## DRAINAGE INFORMATION SHEET

**RE: *Drainage Report and Grading and Drainage Plan for Ayers Residence, Lot 16, Block 13, Tract 3, Unit 3, NAA, (C20/D22) (PWDN 990139) Engineer's Stamp Dated 8/4/99.***

**RE: *Drainage Report and Grading and Drainage Plan for Ayers Residence, Lot 16, Block 13, Tract 3, Unit 3, NAA, (C20/D22) (PWDN 990139) Engineer's Stamp Dated 7/7/99.***

SHAHAB BIAZAR P.E. #13479			
10205 SNOWFLAKE CT., NW ALBUQUERQUE, NEW MEXICO 87114 (505)899-3570			
AYERS RESIDENCE HEC-RAS CROSS-SECTIONS			
DRAWING: 1HEC-SEC.DWG	DRAWN BY: SBB	DATE: 07-06-99	SHEET # 2 OF 2

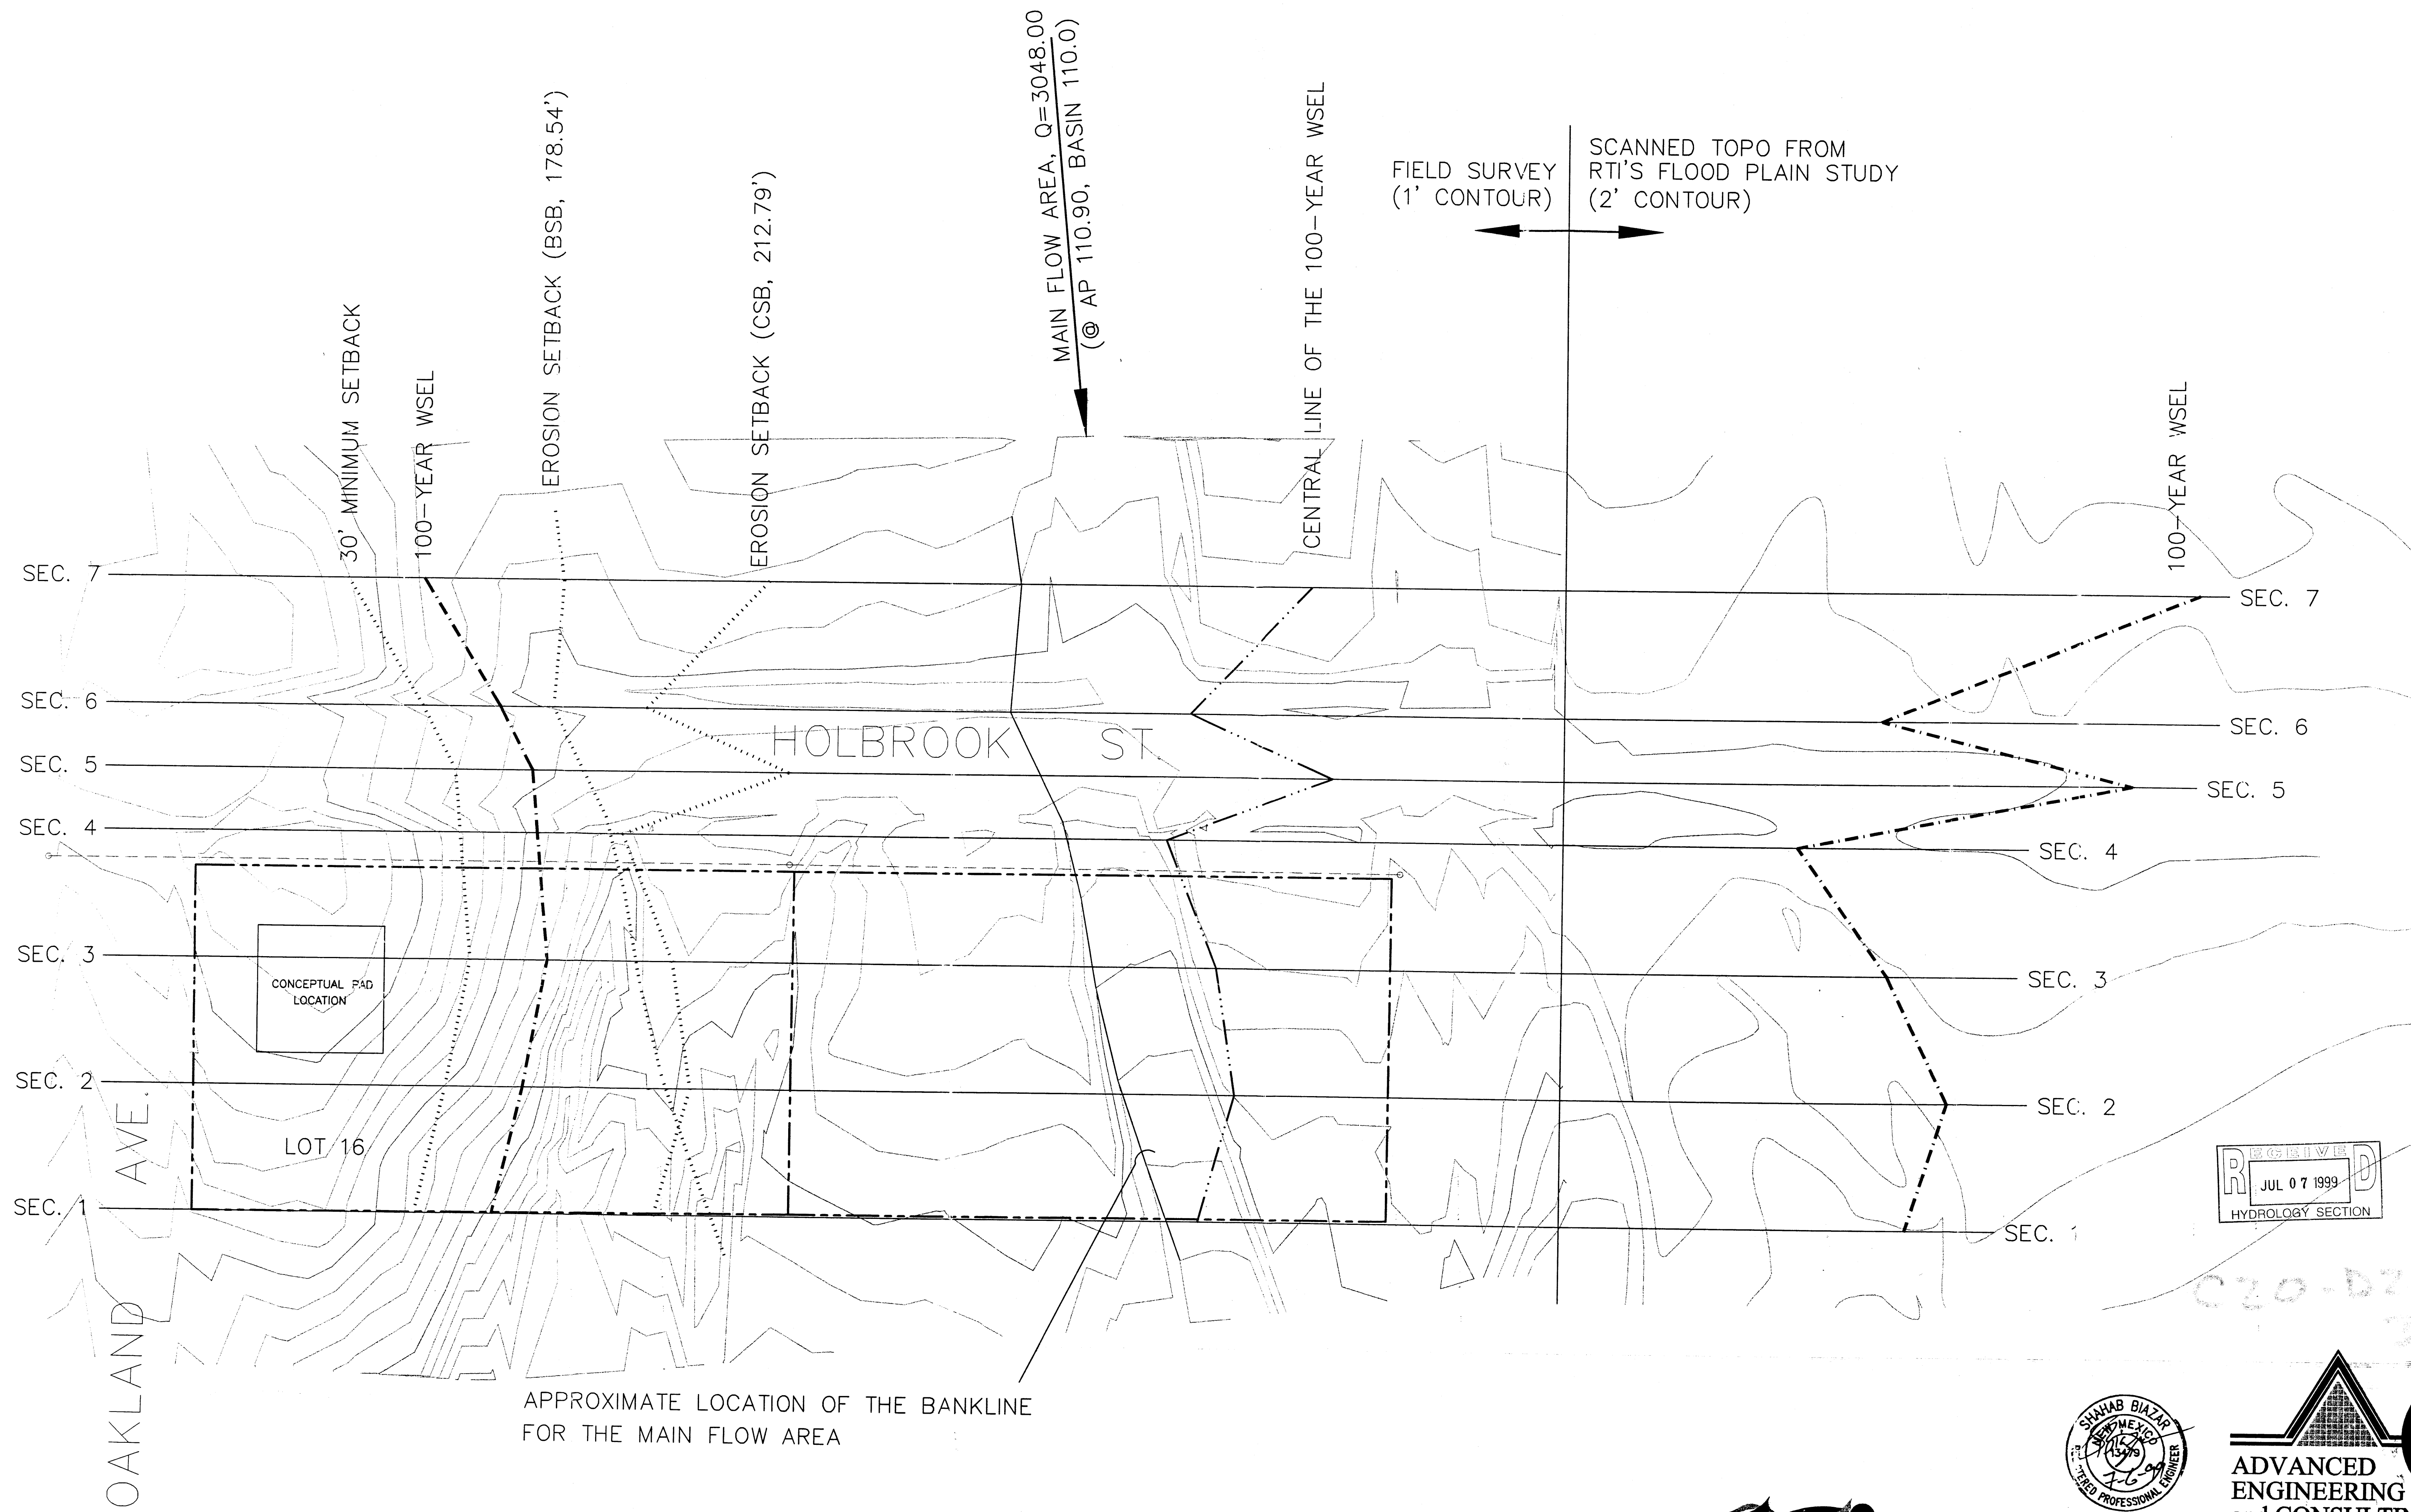
1. This site is located along the main La Cueva arroyo, one of the major arroyos in NAA. Since this arroyo is very wide and braided, predicting the dominant flow path can be difficult. It appears that the runoff from smaller rainfall events may occur predominately within the northern thalweg located just south of this Lot, thus becoming the dominant flow path in the 100-year events. Therefore, it may not be prudent to assume that the dominant flow is 130' south of the property. Please plot the erosion setback (ESB) limits on the plan. Any development proposed within the ESB must be constructed to scour depth, therefore a scour analysis and scour protection is required.

2. The plan shows the limits of the 100-year WSEL. Is this the water surface from your calculations, or the FEMA floodplain limit? Please plot the FEMA floodplain limit on the plan. Also plot the WSEL and EGL from your analysis for comparison. Show the locations of some of the cross sections through the Lot on the plan. Also plot the energy grade line (EGL) and proposed AMAFCA easement. Is the finish floor elevation higher than the EGL?
